HVAC permit for Park Danforth, 777 Stevens Ave

There were just a couple questions that I wasn't able to fully determine from the submitted mechanical plans:

CONTENT:	
MECHANICAL PART PLAN - LEVEL 1 - MAIN STREET	
DRAWN BY:	REB
PROJECT NO.	1209430
DATE	08/02/2015
REVISION	OCTOBER 16, 2015
SCALE	AS SHOWN
MH1.1A	
Project Name	
COMFORMANCE SET	
COPYRIGHT © 2015 JAVALLEE BRENSINGER ARCHITECTS ALL RIGHTS RESERVED. MECHANICAL ENGINEERING

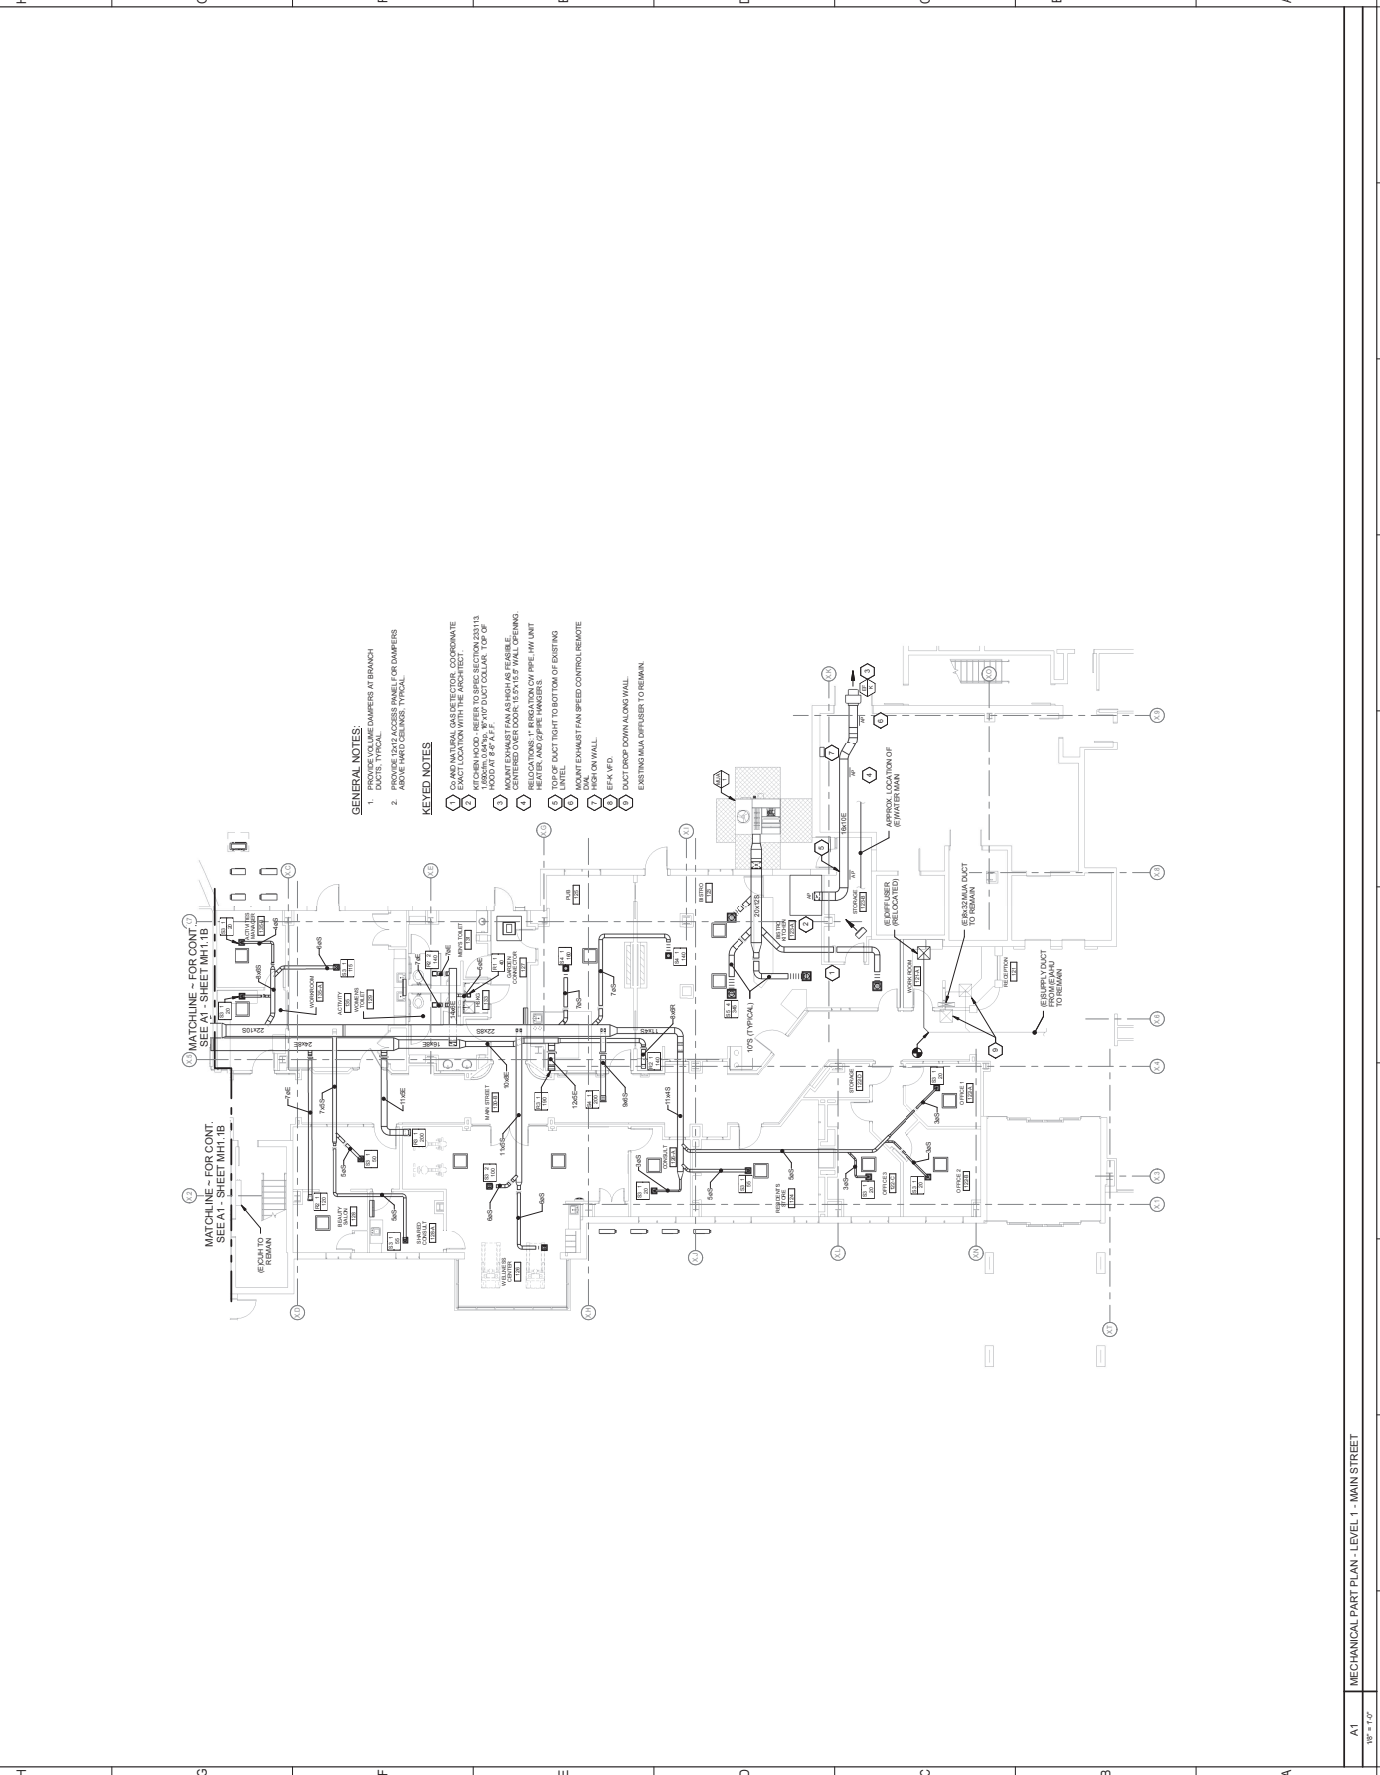
2) Are there any new ground-level exterior units being placed on the property? The only place where I thought there might be one is on plan MH1.1A, but I wasn't positive if I was reading the plan correctly. If there are any, will they be screened and not visible from public ways?

2) Are there any new ground-level exterior units being placed on the property? The only place where I thought there might be one is on plan MH1.1A, but I wasn't positive if I was reading the plan correctly. If there are any, will they be screened and not visible from public ways? There are no units on the ground level. Originally, unit MUA-1 was shown on the ground level, but this unit has since been removed from the project.

A1 MECHANICAL PLAN - ROOF - NEW BUILDING
 1/8" = 1'-0"

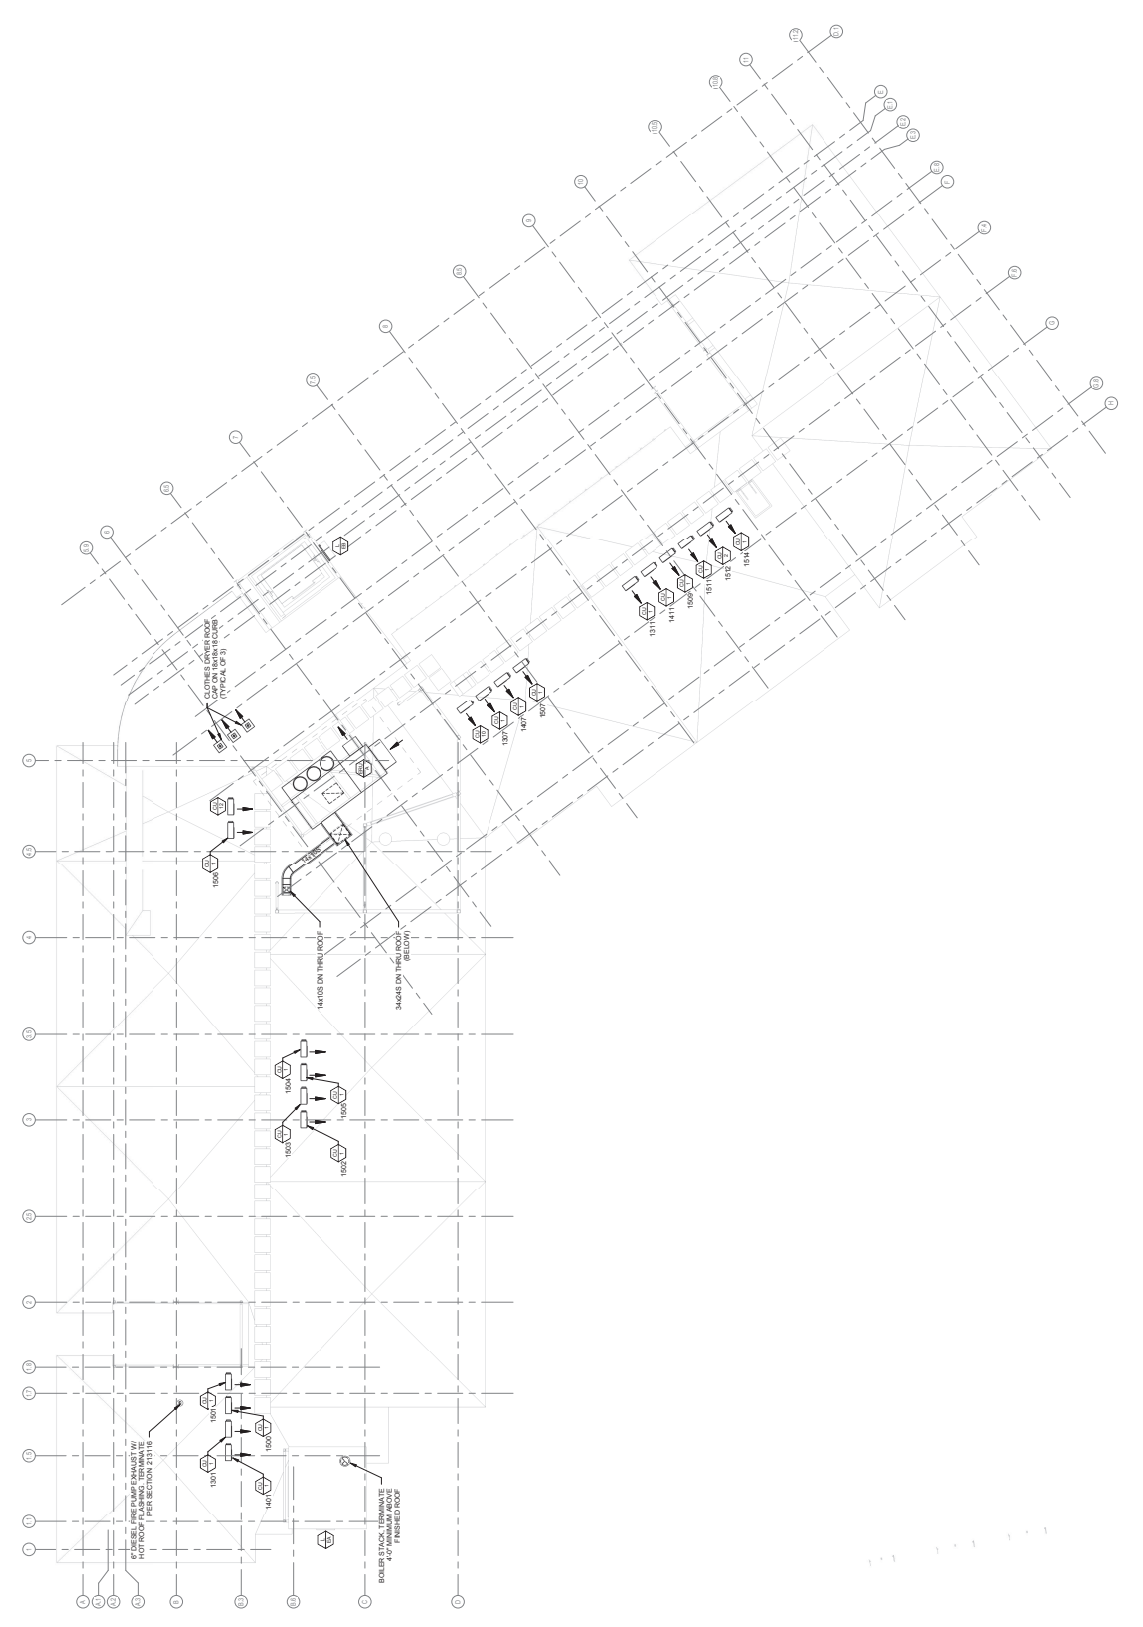
1) Will the roof-mounted unit be visible from the road at all? It appears to be set back on the roof far enough that it won't be visible (particularly given the height of the building), but I wanted to verify. If it will be visible, screening is required, per the Planning Board approval.

Andrew, thanks for the info. Just one last question of clarification - is the rooftop unit "screened" simply by virtue of its location, or will something actually be constructed to block the view?

1) Will the roof-mounted unit be visible from the road at all? It appears to be set back on the roof far enough that it won't be visible (particularly given the height of the building), but I wanted to verify. If it will be visible, screening is required, per the Planning Board approval. The units on the roof are screened.

Andrew is tied up right now, but I wanted to get back to you. The equipment is fully screened by either a parapet wall or louvered equipment screens depending on the condition.
